Rezoning Transportation Analysis
Petition Number: Insert Zoning Petition #2022-029
General Location Identifier: 08108415

Date	Description
07-24-2022	First Review (AO)

The site is located on Seigle Avenue, a City-maintained minor thoroughfare, and Van Every Street, a City-maintained local street. A Traffic Impact Study (TIS) is not needed for this site. Site plan revisions are needed to meet ordinance requirements and/or the outstanding items including, but not limited to listing out the proposed phasing for transportation and site improvements. Further details are listed below:

Skyline Townes
Rezoning Site Plan
 955 Seigle Avenue Charlotte, North Carolina

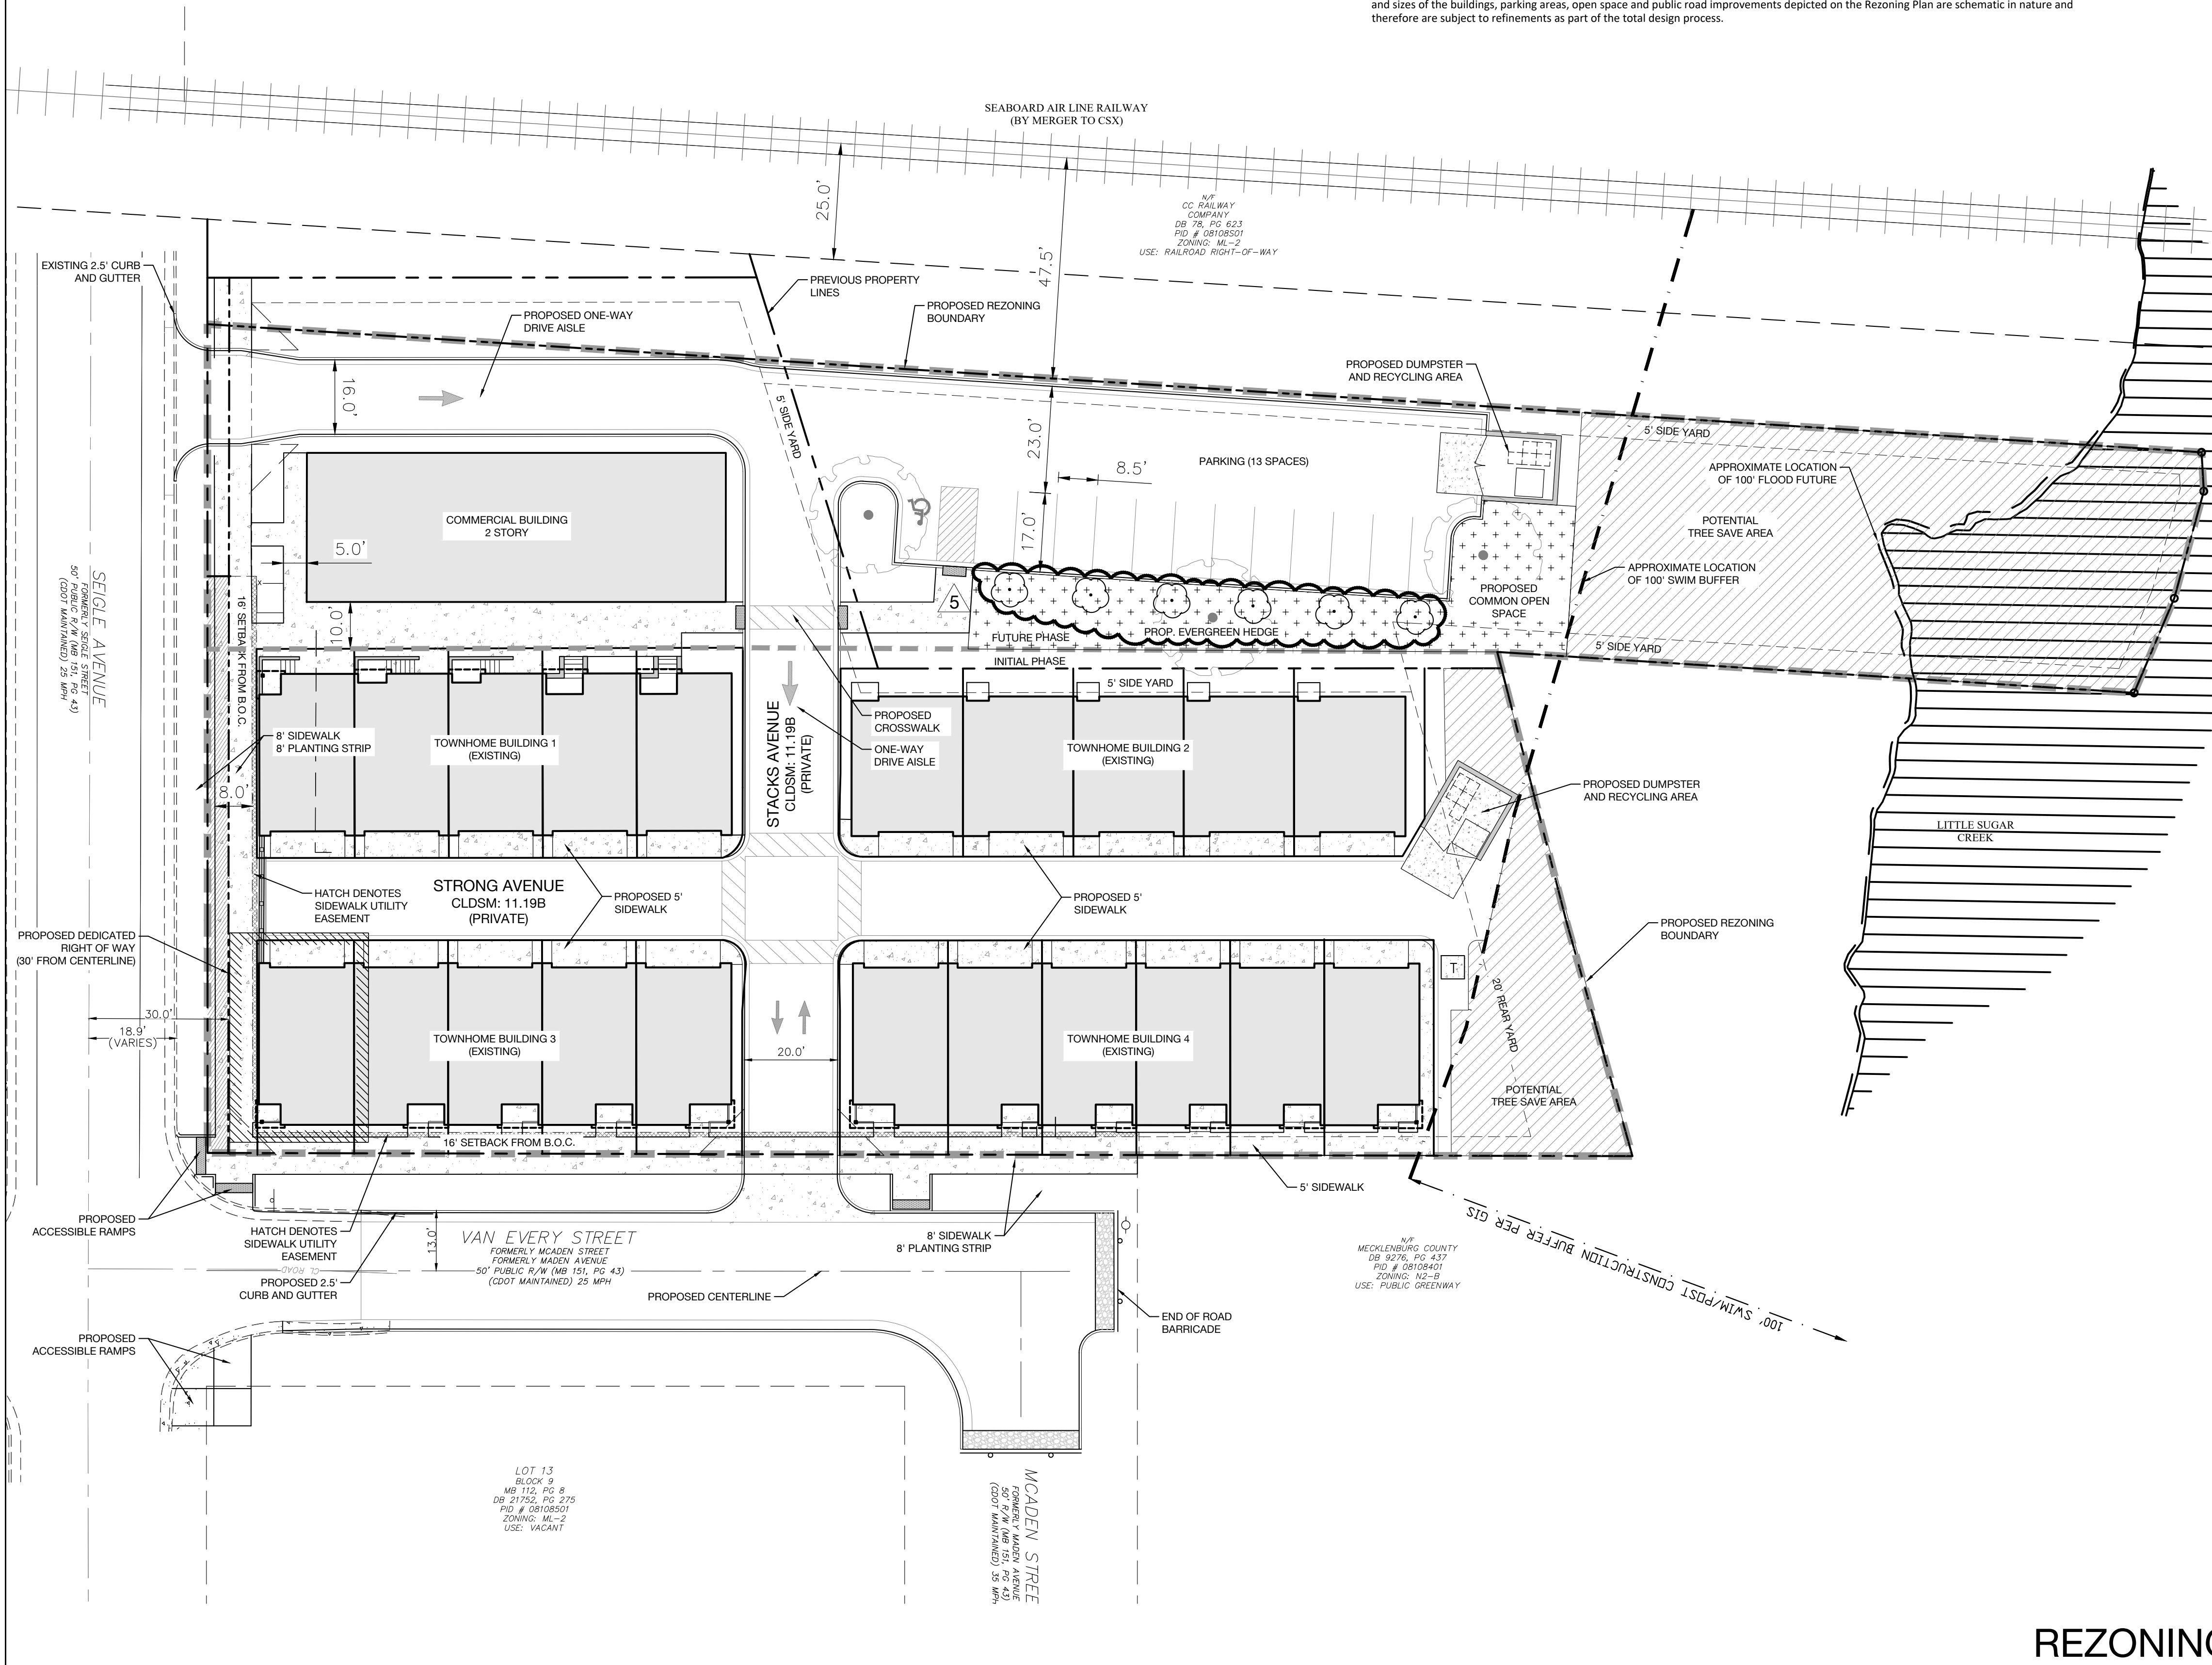
2. Revise site plan and conditional note(s) to list out proposed transportation and site improvements and their proposed phases (initial, future).
